Consultation Response from: KC Environmental Health (Pollution & Noise Control)
2024/91995 Calder View, Lower Hopton, Mirfield, WF14 8JD
Discharge of details reserved by condition 9 (gas protection) of previous permission 2017/90557 for erection of 99 dwellings
Responding Date:
16th January 2026
Responding Officer:
SR
Responding Ref:
WK202606753
Comments

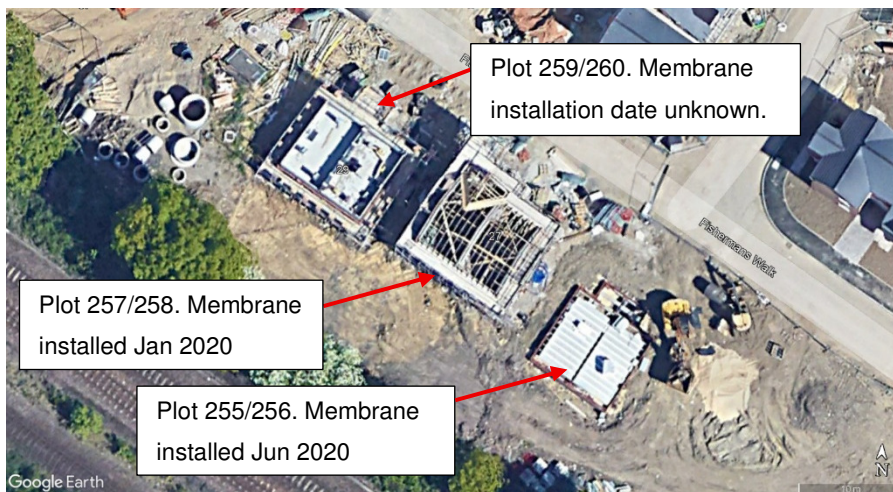
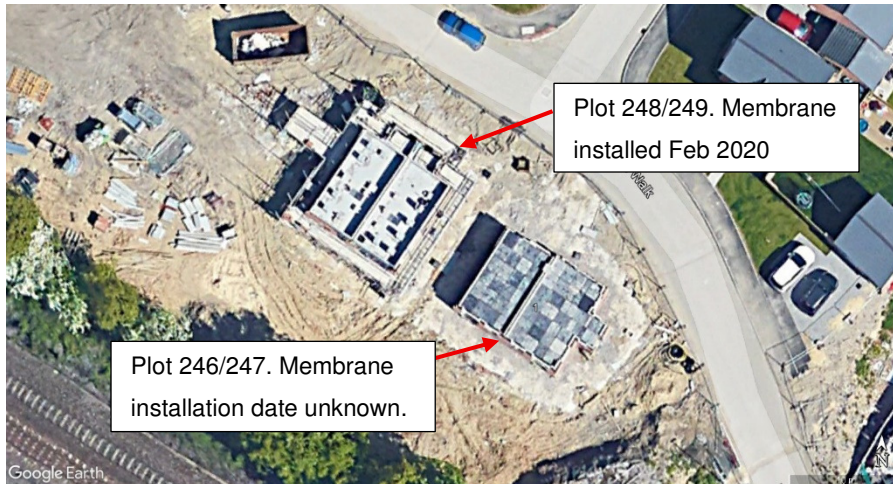
There is no documentary evidence of gas protection measures for plots; 232,233,241,246,247,259,260,265,267,280. The letter suggests we should rely on satellite images of the site for verification purposes, which does not follow the implementation plan by Lithos or good practice guidance.

The letter author informs; *“It is likely that the gas protective measures for these plots would have been installed at the same time and Remedial measures have been installed broadly in accordance with Lithos’ Implementation Plan.”* Words such as “likely and broadly” do not provided a sufficient level of confidence in the information provided, we therefore do not accept the additional information provided and condition 9 (gas protection), must remain.
